RE: LAND SOUTH OF SOUTH SIDE, STEEPLE ASTON

Please find enclosed an application made by Rectory Homes proposing a minor-material amendment to approved application 21/02318/F. The application has been submitted via the Planning Portal (ref: PP-11323155).

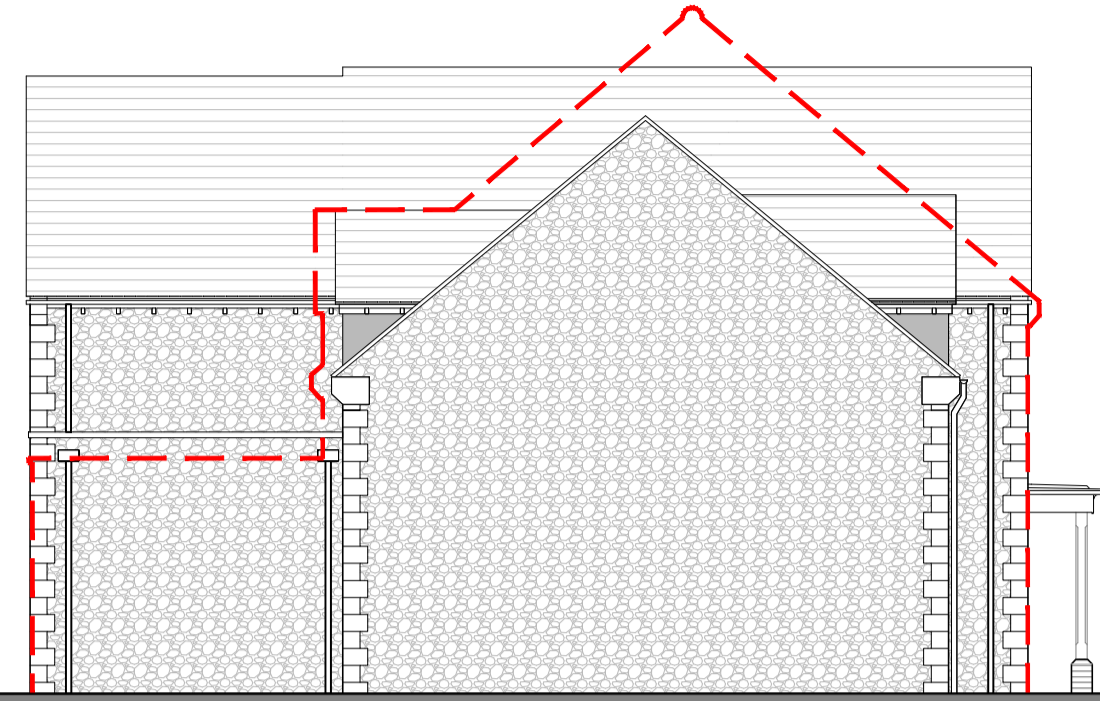
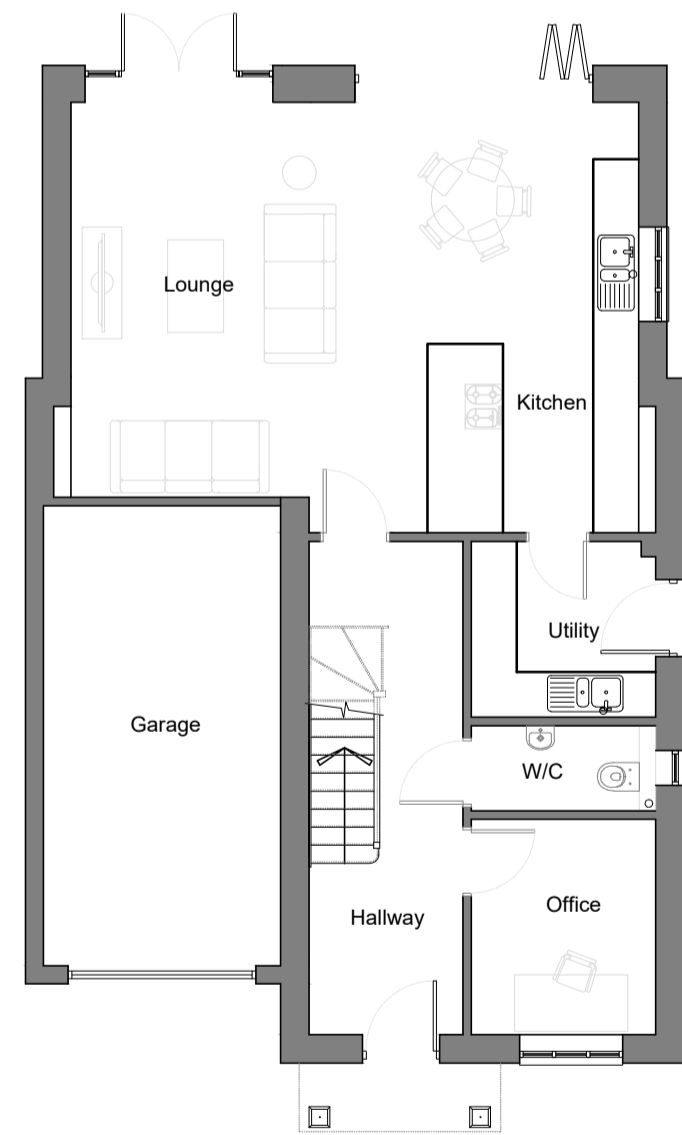
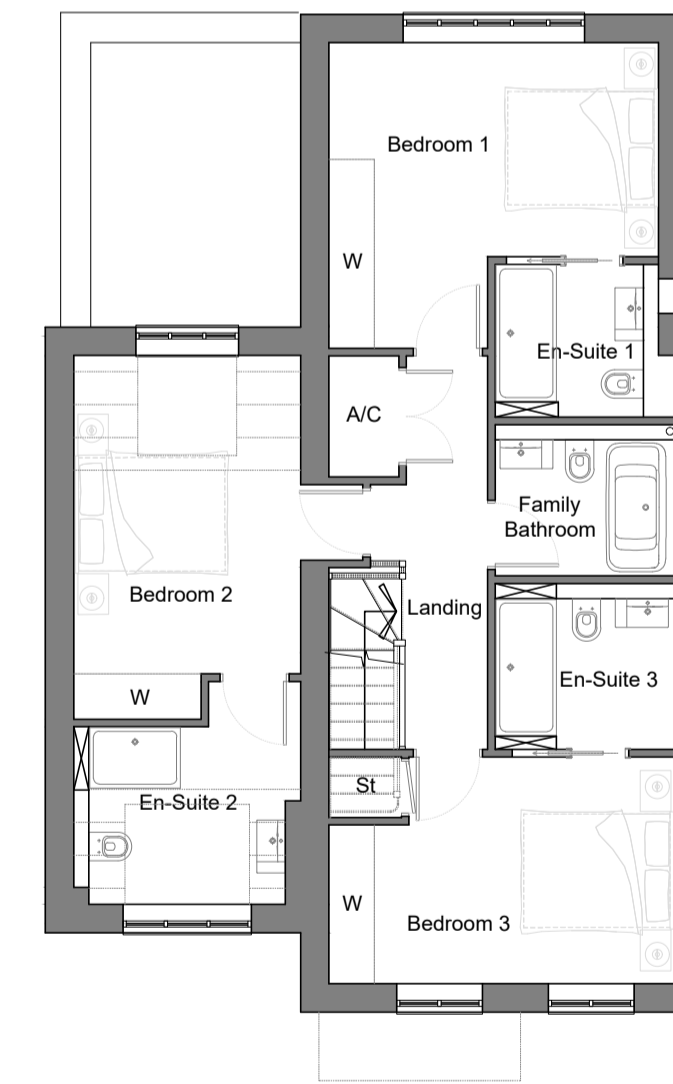
Rectory Homes are seeking approval to alter the design of plot 10 to reflect the requests of a purchaser. It is considered more efficient to establish approval for the changes now before the site is built out than seek to amend a fully constructed property. The proposed amendments to the plot are listed below:

- Alteration of the form of the plot to a gable-fronted property;
- Enlarged and centralized dormer window on principal elevation;
- Two-storey rear extension in place of approved single-storey extension;
- Re-arranged kitchen and lounge area with the home office re-positioned at the front of the dwelling;
- Enlargement of bedroom three from single to a double bedroom with ensuite.

The amended form of plot 10 reflects plots 4 and 7 insofar as they are both gable-fronted properties with a narrow front elevation and which extend within the rear curtilage. The proposed roof pitch is comparable to these plots and the length of plot 10 is also similar in terms of footprint.

Given the new building form, the dwelling will appear smaller from the front of the site with less massing and a reduced ridge height. The submitted elevations and floor plans drawing shows a comparison between the approved plot 10 form (shown as a broken red line) against the proposed amendments. An updated street scene drawing is also provided to demonstrate how the amended dwelling form will fit in with the rest of the scheme when viewed from the site entrance. It is considered that the amended form to plot 10 sits comfortably on the site, is in keeping with the design ethos of the overall scheme and provides a better proportioned plot than the previously approved iteration.

The additional dwelling space is provided through the amended side elevation which changes from a gabled form and single-storey extension to the rear to a more rectilinear form. This elevation will not be seen from any public viewpoints with the western elevation of the site heavily screened by existing and new landscaping / trees and additional intervening trees along South Side. As such, it is considered the impact of the proposed changes is negligible.
